**STATEMENT OF ENVIRONMENTAL EFFECTS: SECTION 75W APPLICATION TO MAJOR
PROJECT MP NO.08_0257 STAGE 1 (BUILDINGS 4 & 5) – 61 MOBBS LANE, EPPING**

Pursuant to Section 75W (1) (a) of the Environmental Planning and Assessment Act 1979, a 'modification of approval' is sought to vary Condition No. A2 pertaining to Major Project MP No. 08_0257 Stage 1 (Buildings 4 & 5) as approved on the 15 September 2010. The modification is to amend architectural plans to accommodate minor design changes to the approved architectural plans arising from design and construction compliance.

Client: Merton Apartments Pty Ltd
Architect: PTW Architects
Drawing: Building 5 North & South Elevations
Project: Epping Park
61 Mobbs Lane, Epping
Stage 1 (Building 4+5)
A5202
SECTION 75W ISSUE
REVISION: B

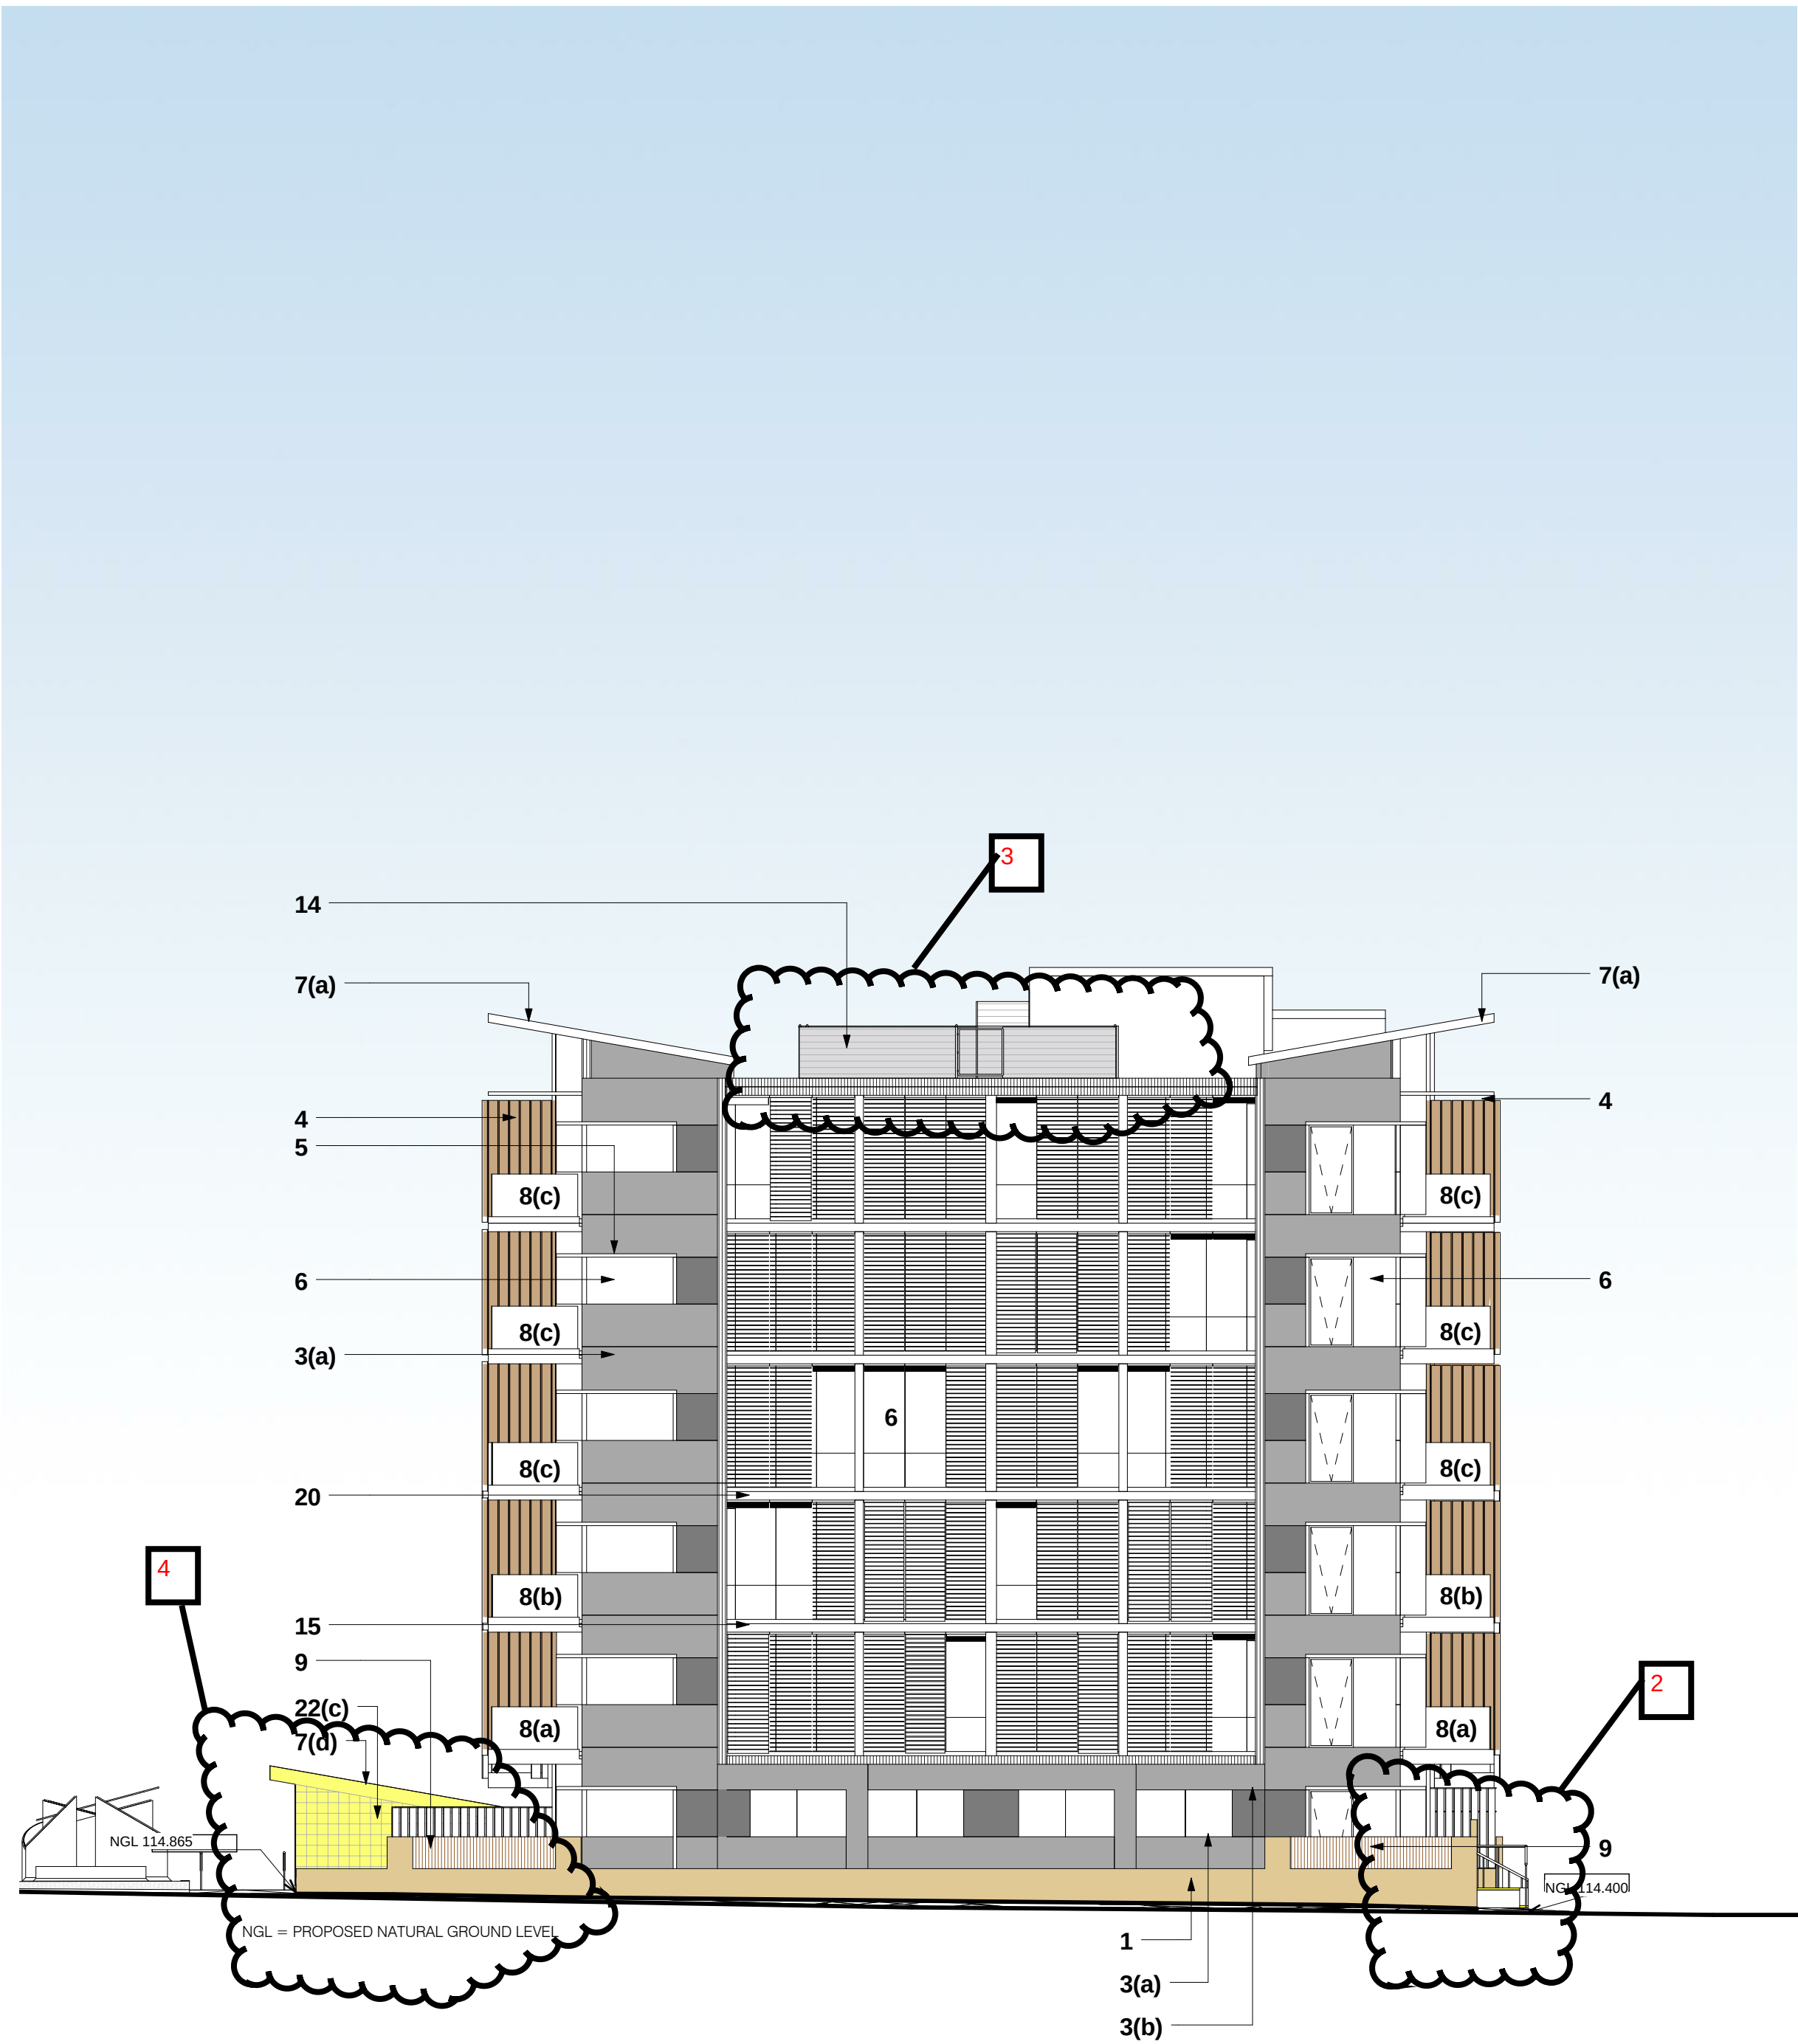
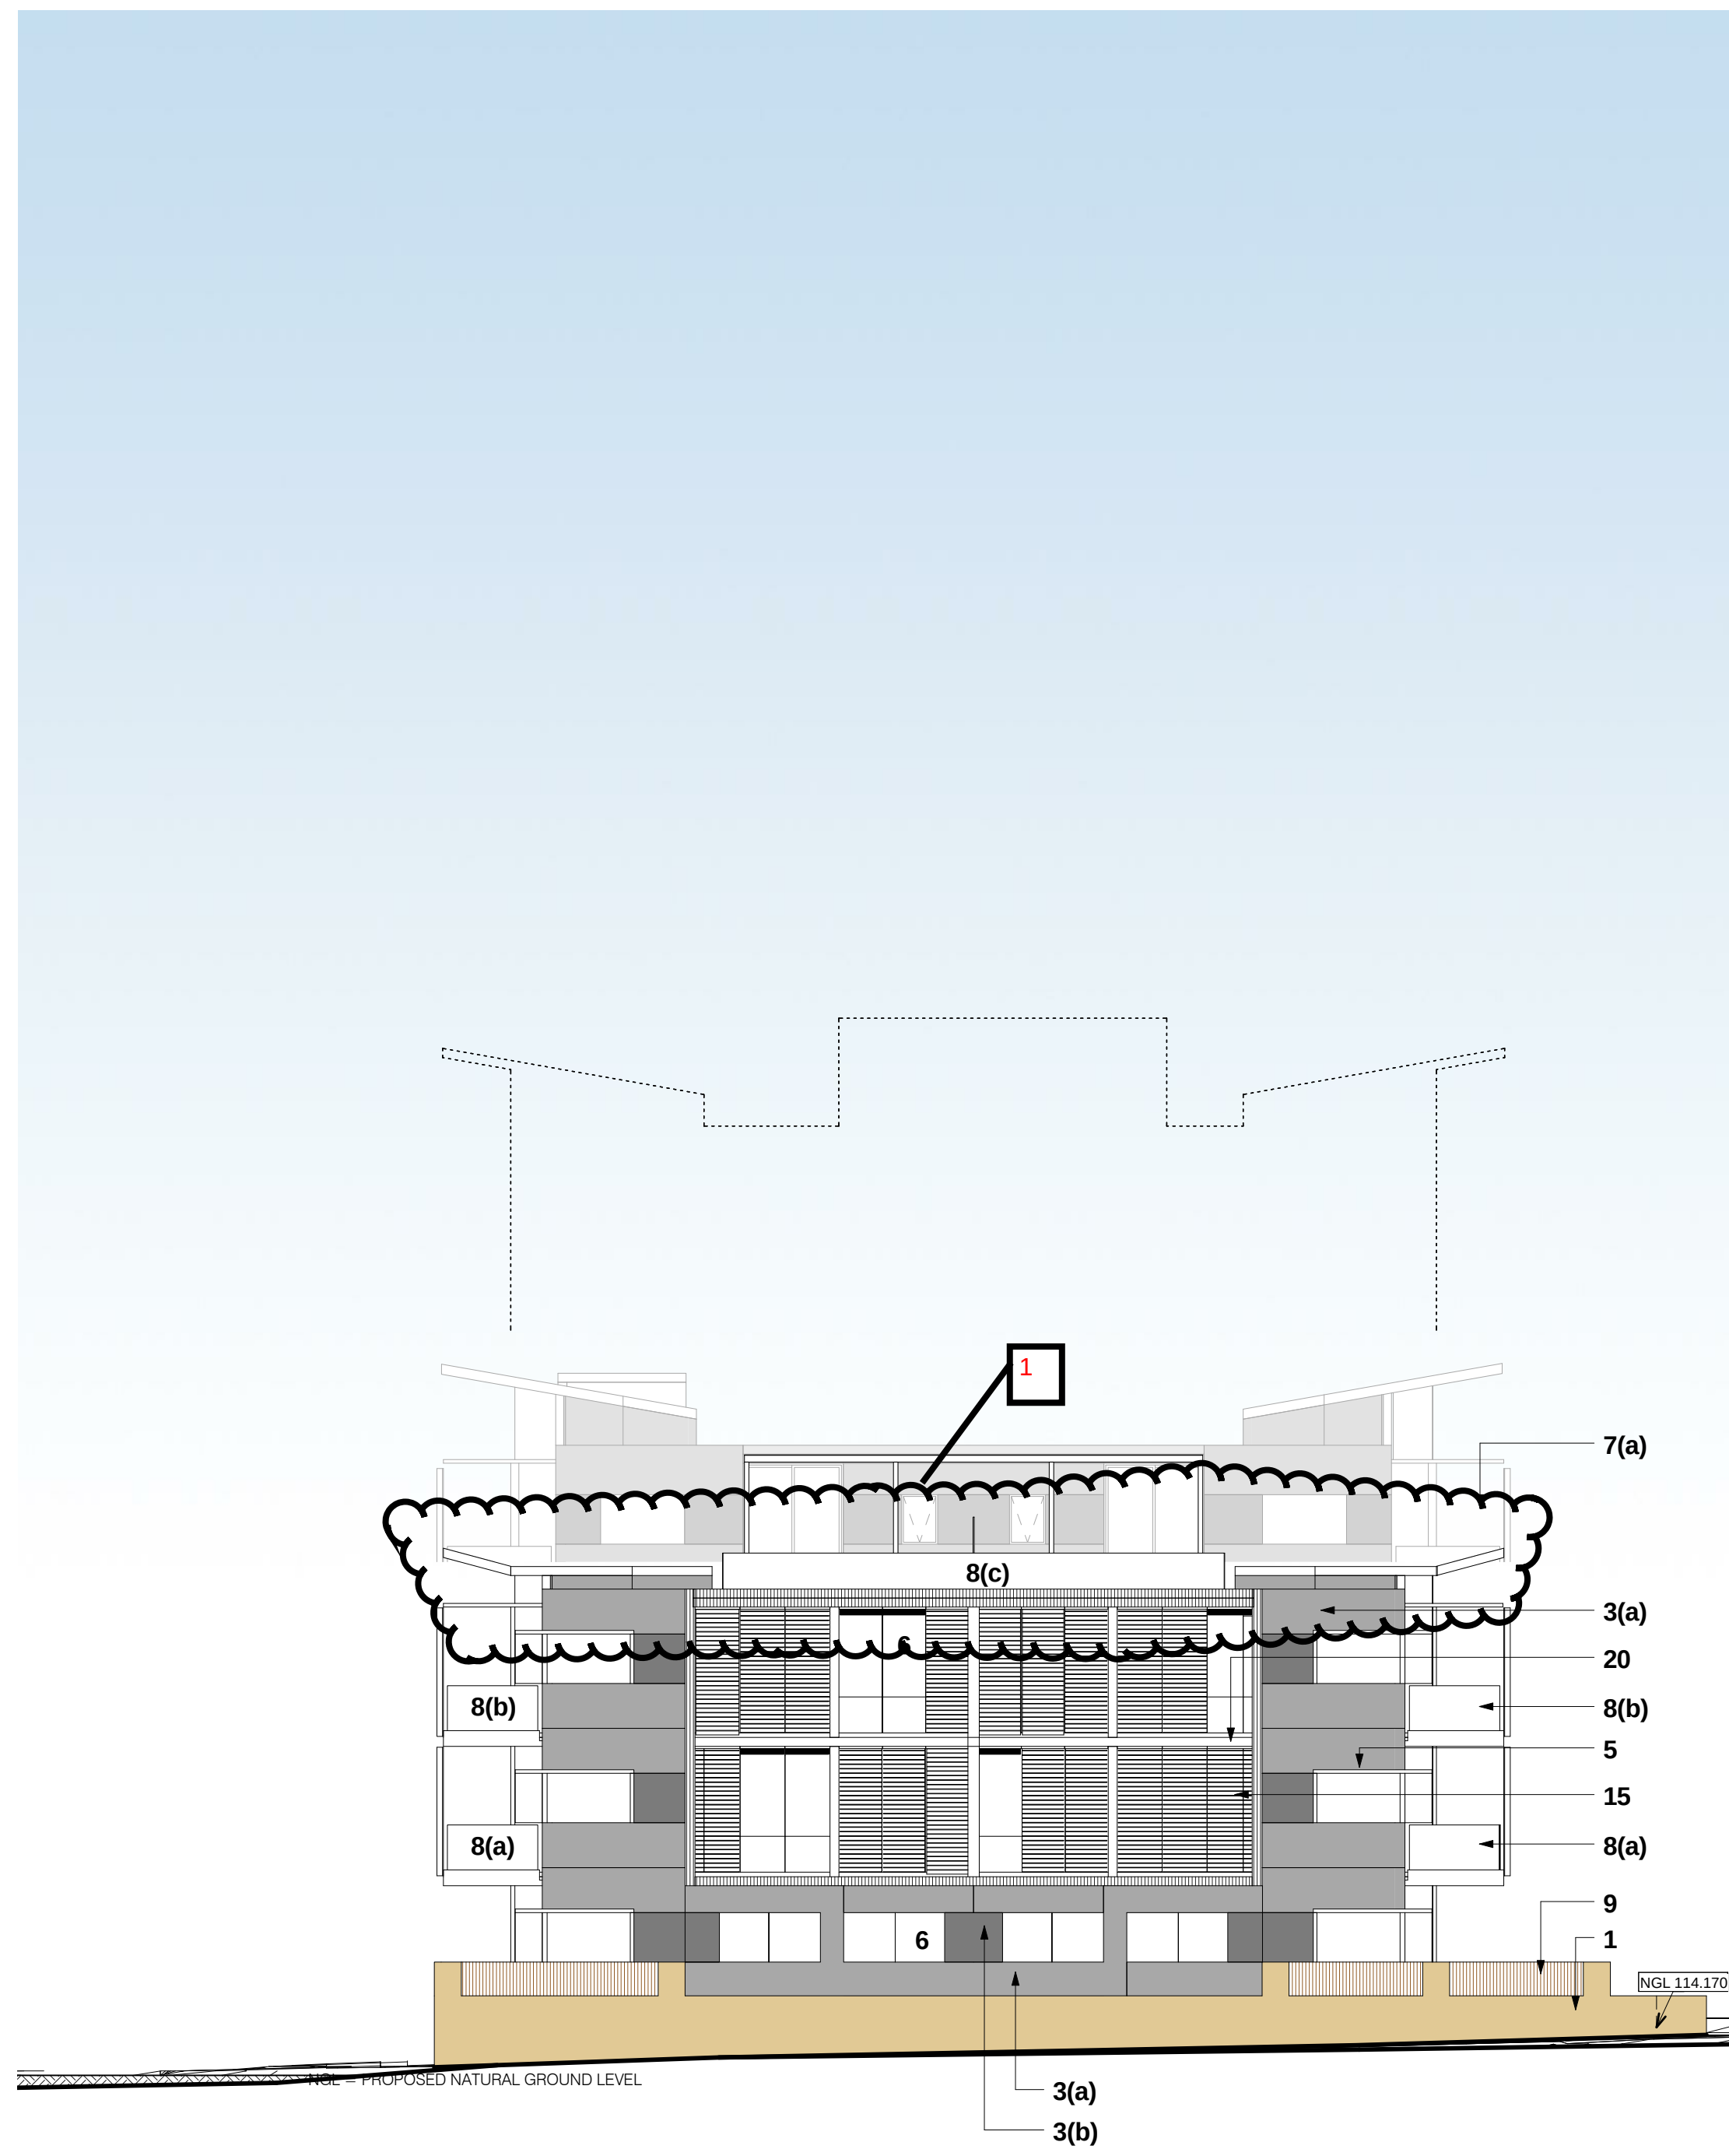
1. Roof reconfiguration
2. Louvre and stair detail added
3. Roof reconfigured
4. Garbage room and roof details reconfigured
5. Colour legend amended

1. Roof reconfiguration
2. Louvre and stair detail added
3. Roof reconfigured
4. Garbage room and roof details reconfigured
5. Colour legend amended
